ENG-PUDSP21002-R1-GEC.pdf Markup Summary

OVERLOT GRADING / E

**SKYLINE AT LORSON RANCH AND
 OVERLOT EARLY GRADING AND
 EROSION CONTROL PLAN**

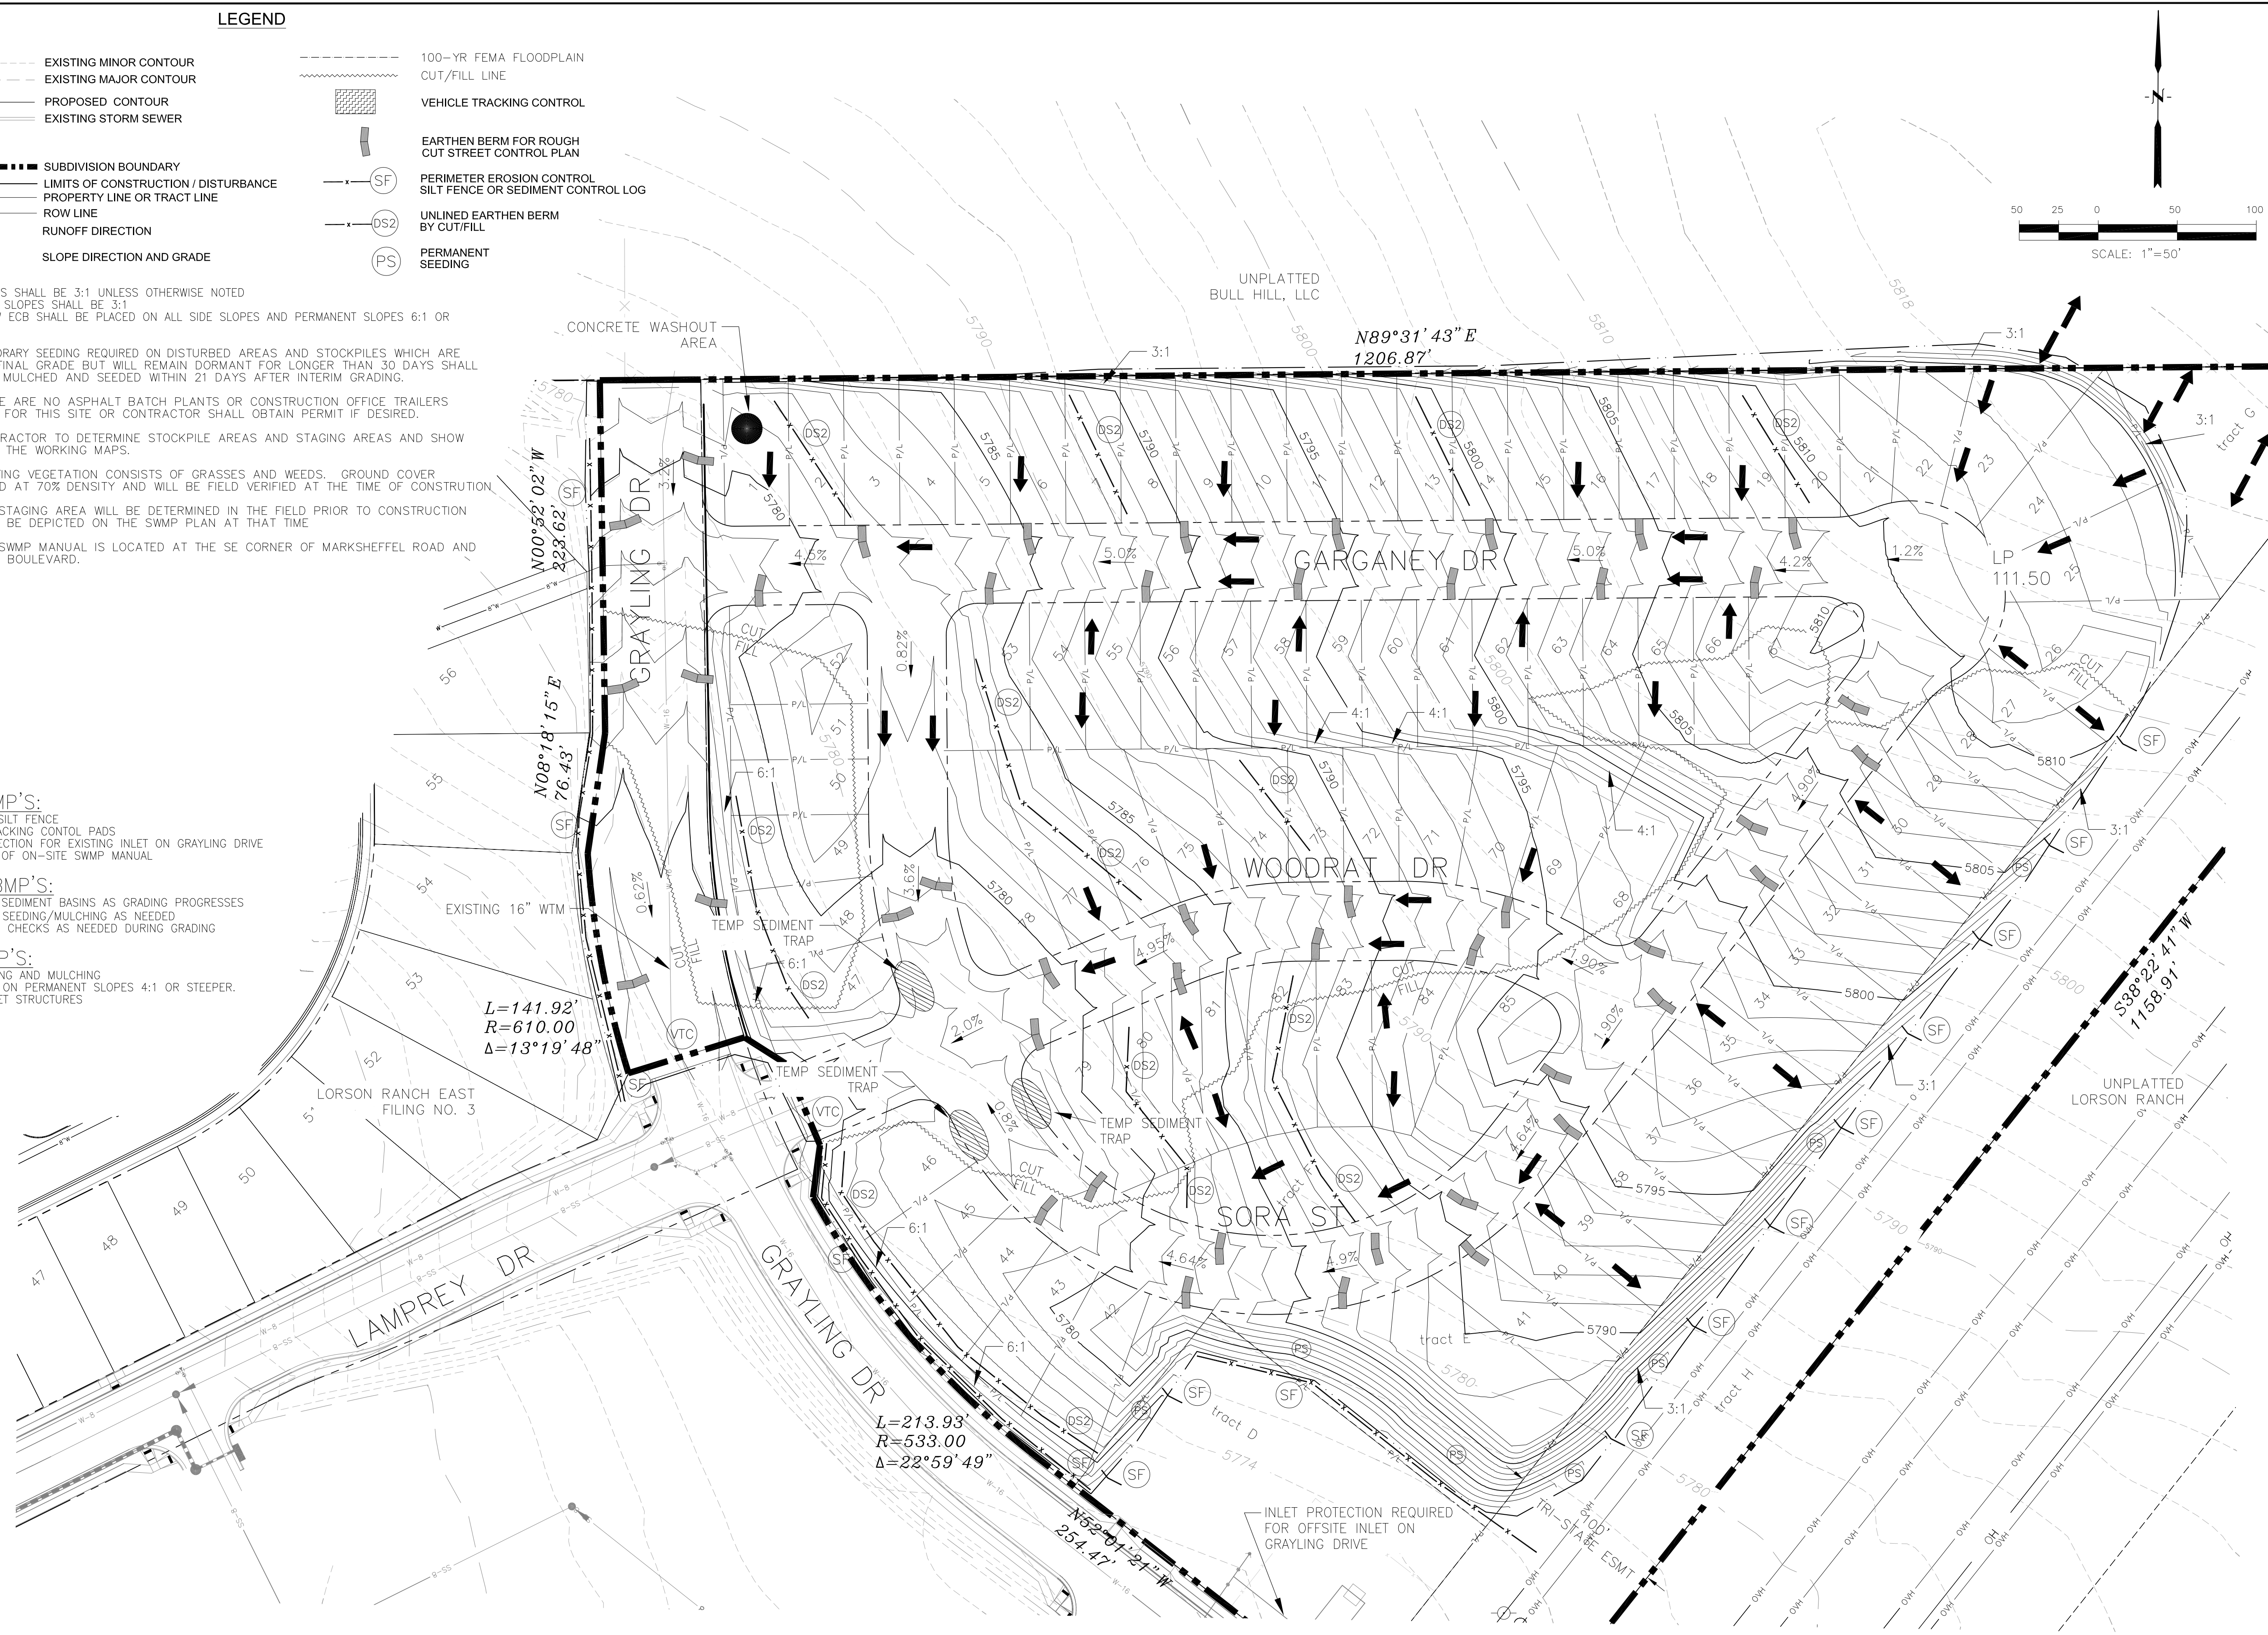
Sediment traps are for drainage areas less than 1 acre. Please use sediment basins at the Site.

Call out as offsite grading. Need owner permission to grade offsite. Provide copy of owner permission to EPC.

Please differentiate between silt fence and sediment control log

stormwater flow arrows should be perpendicular to contours in order to accurately depict stormwater flow direction.

May need to include temporary drainage ditches to direct stormwater to sediment basins

Please show entire subdivision on figure or split into two Sheets. It looks like there is offsite area at the top of the drawing that can be cut out to make room for this important part of the Site.

show existing pump station

Is there a fence here? if so, is it going to remain in place or be removed during grading?

TYPICAL "A" LOT

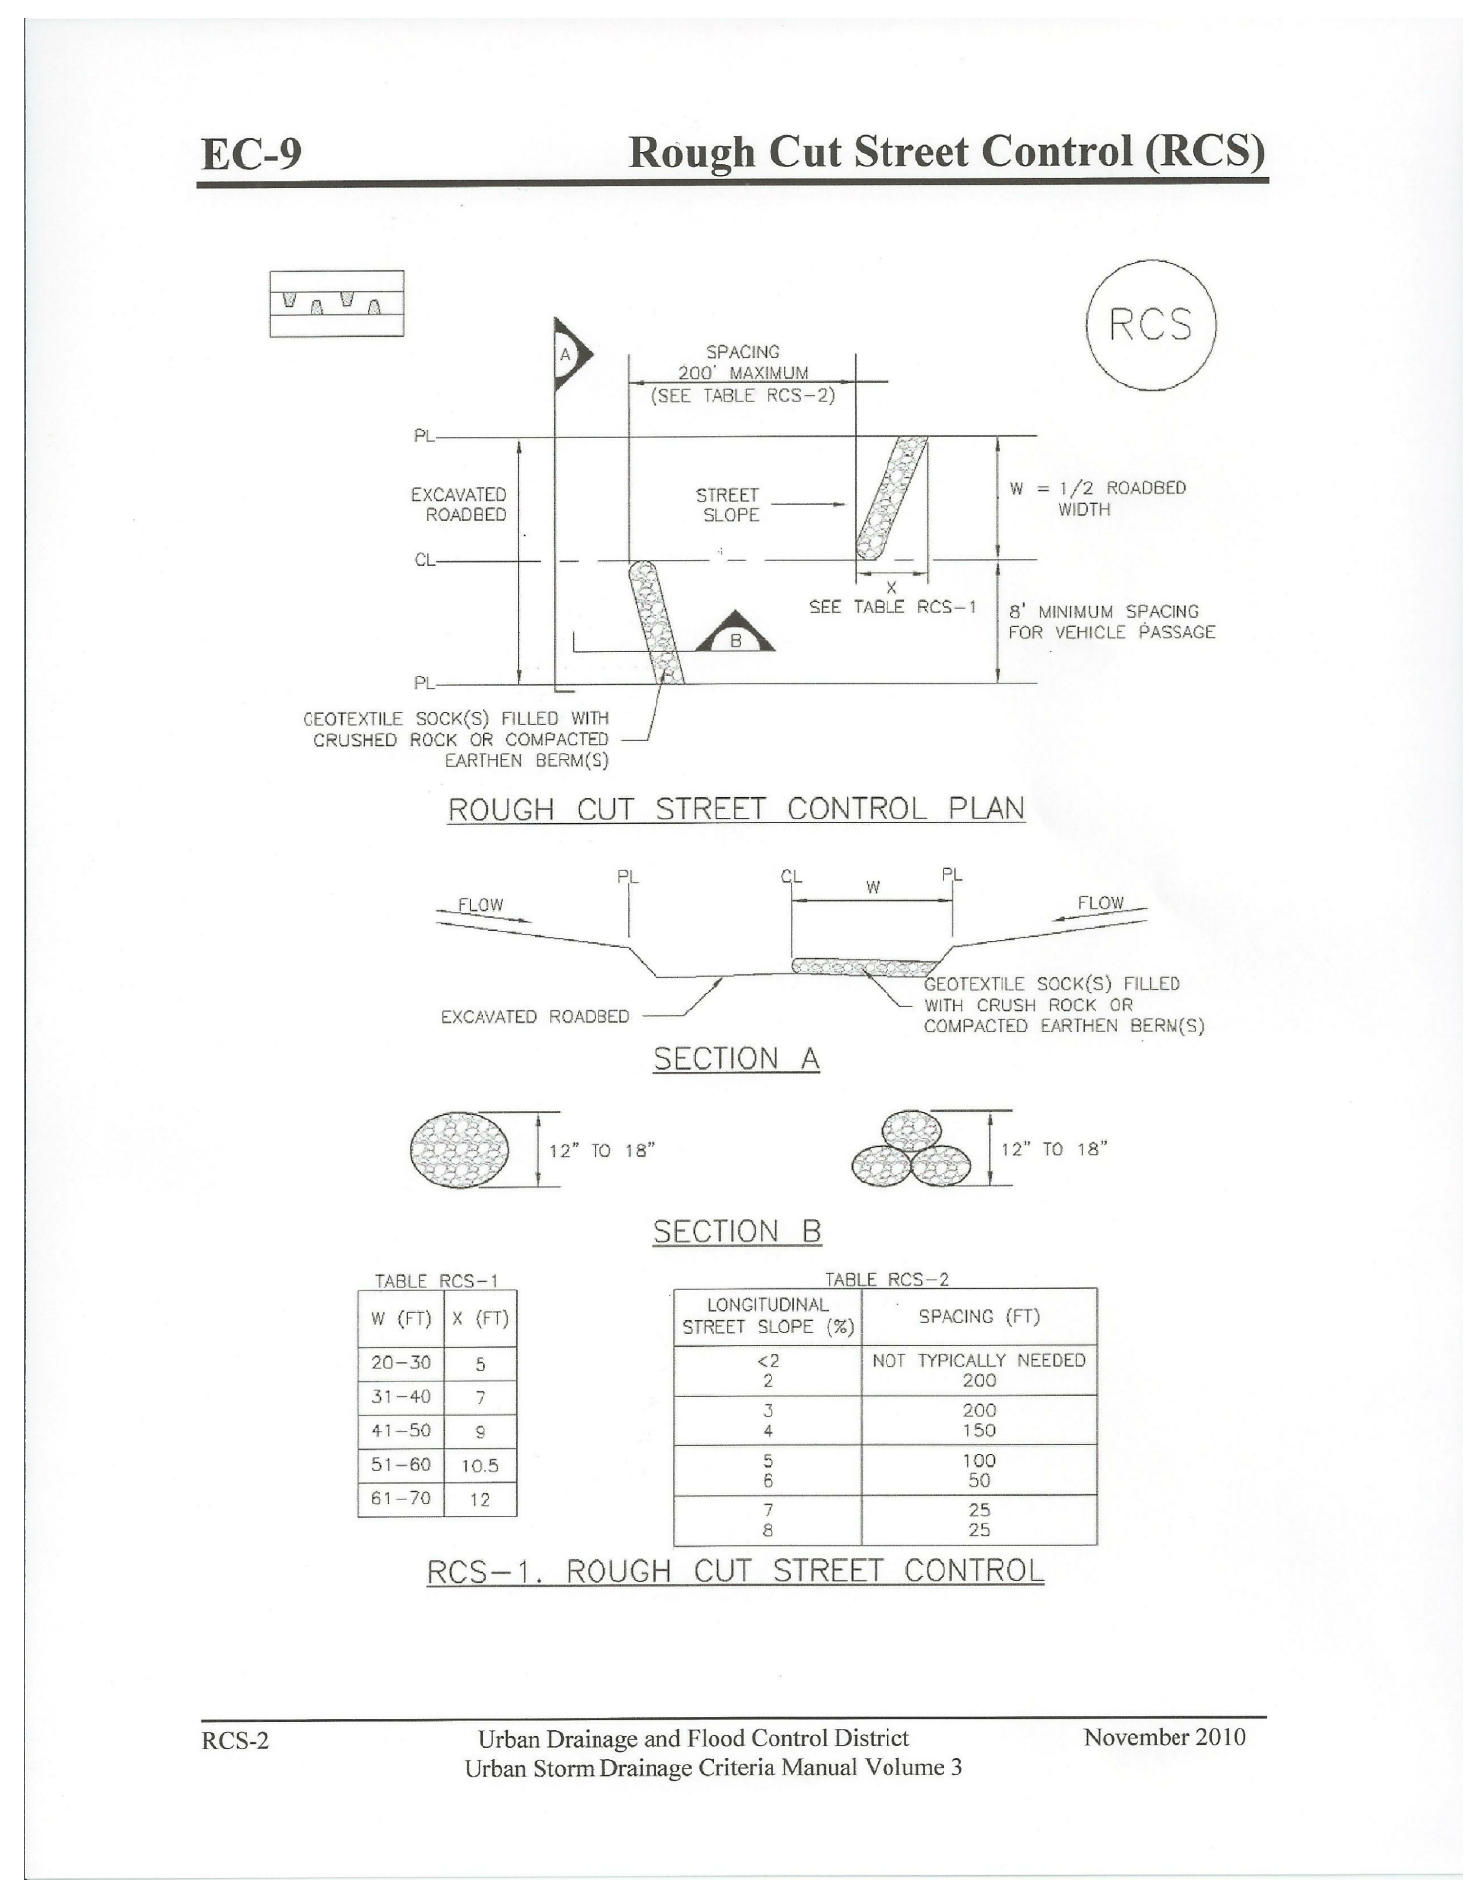
Provide details showing side-lot swales required of builders and typical section of swale between lots.
